PROPERTY AT 20 AVON ROAD, PYMBLE

PYMBLE LADIES COLLEGE – GREY HOUSE PRECINCT SSD-17424905

State Significant Development SSD-17424905
 Pymble Ladies College – Grey House Precinct
 20 Avon Road, Pymble (Lot 1 DP 69541)

Table 1 RESPONSE TO INFORMATION REQUEST

Visual Privacy of adjoining context

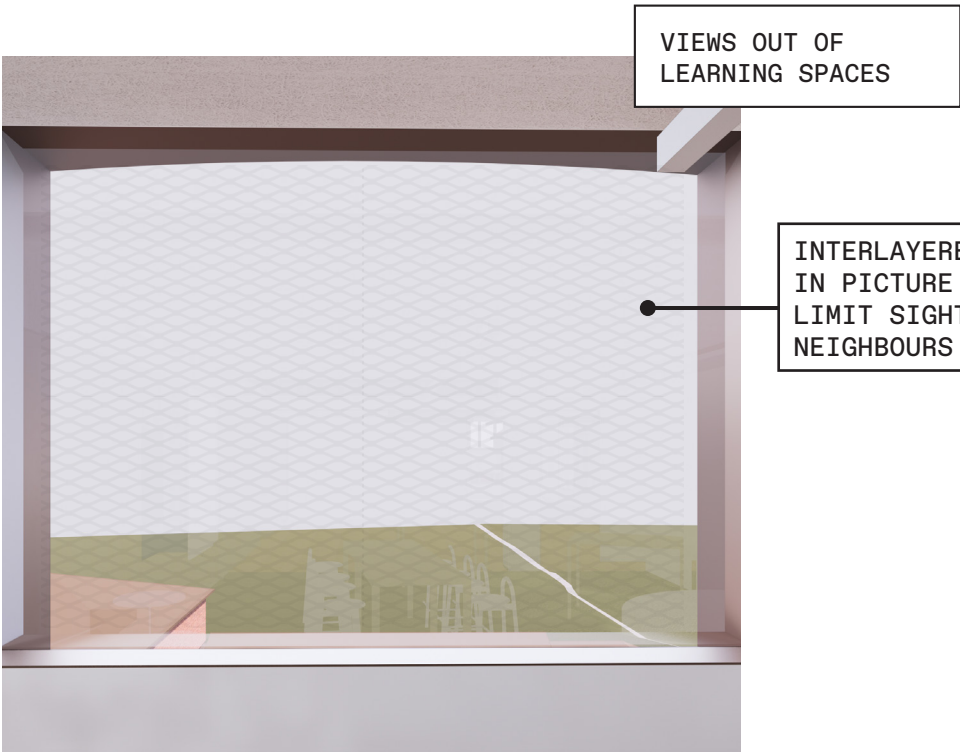
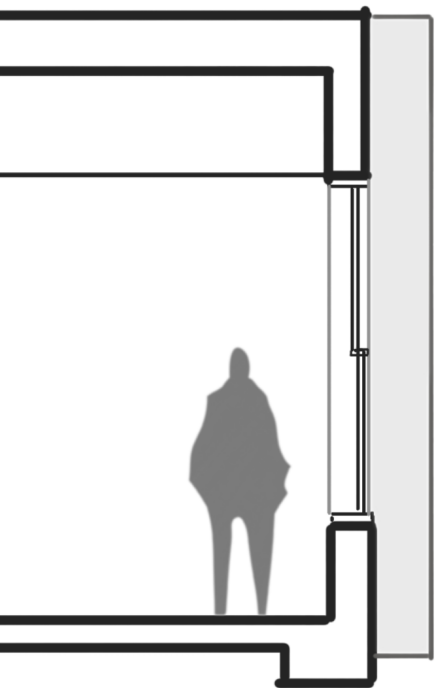
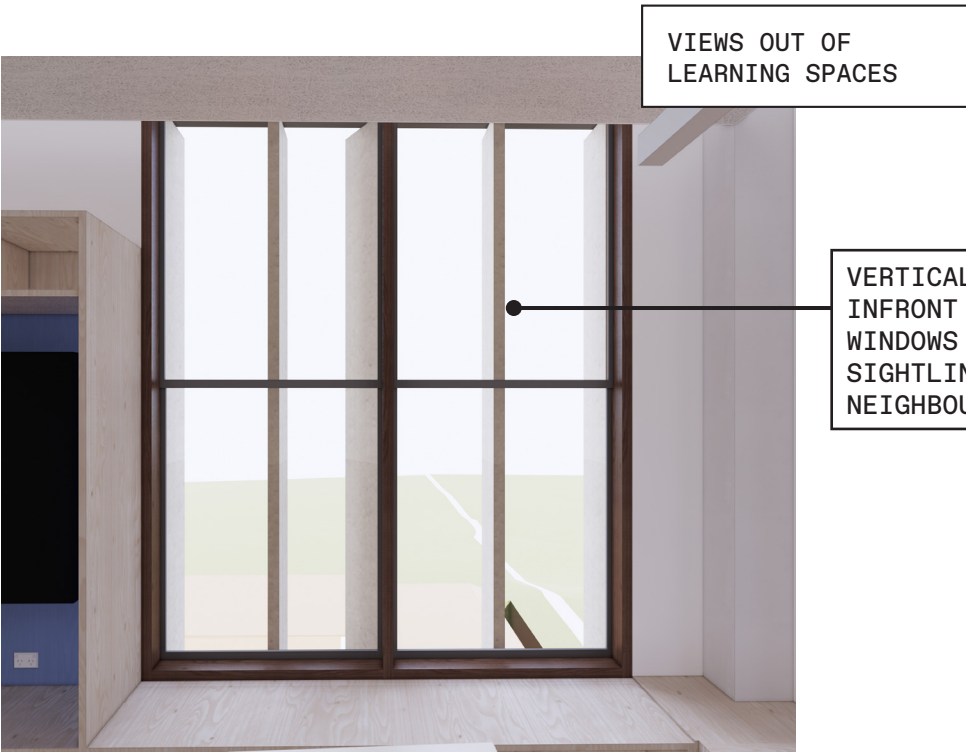
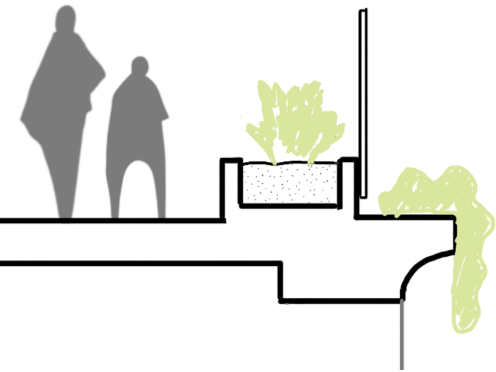
<p>5. The Department notes the justification provided with regard to overlooking and visual privacy. However, the Department is concerned that the level 3 classroom windows and level 2 balcony of the proposed building may directly overlook on to the swimming pool</p>	<p>The Design Report addendum, at page 5 (Appendix 3) has shown the distance between the GHP building window line and the adjoining building, being 24m and 30m respectively. There is little opportunity from these windows, through the design of the window elements, distance and angles, into the neighbouring property or their amenity areas.</p>

<p>and courtyards of the residential properties to the south (facing Pymble Avenue). In this regard, the Department requires you to provide a more detailed view analysis diagram to demonstrate the extent of such overlooking (if any). Should the development result in adverse impacts on the privacy of the neighbouring properties, alternate solutions such as privacy glazing (obscure glass) or highlight windows should be explored and included in the design.</p>	<p>As part of the proposed landscape plan, a row of large Blue Gum trees will be planted along the length of the site boundary, providing a landscaped buffer and adding to the existing garden setting of Pymble Avenue. However, view out towards 57A and 59B from the learning spaces have been tested without the trees and indicate very little overlooking opportunities. The interlayered mesh in the picture window and vertical screening in front of the operable windows further obscure sightline into neighbouring properties and their amenity area.</p> <p>In the L02 outdoor terrace area, landscaping elements have been incorporated to the perimeter which creates a setback to restrict sightline. The 1.8m tall balustrade further limit overlooking opportunities into the neighbouring properties and their amenities area. This is further explored in the Design Report Addendum at page 6 (Appendix 3).</p> <p>Should this not be considered satisfactory, further obscure glazing to these windows can be conditioned accordingly by DPE.</p>
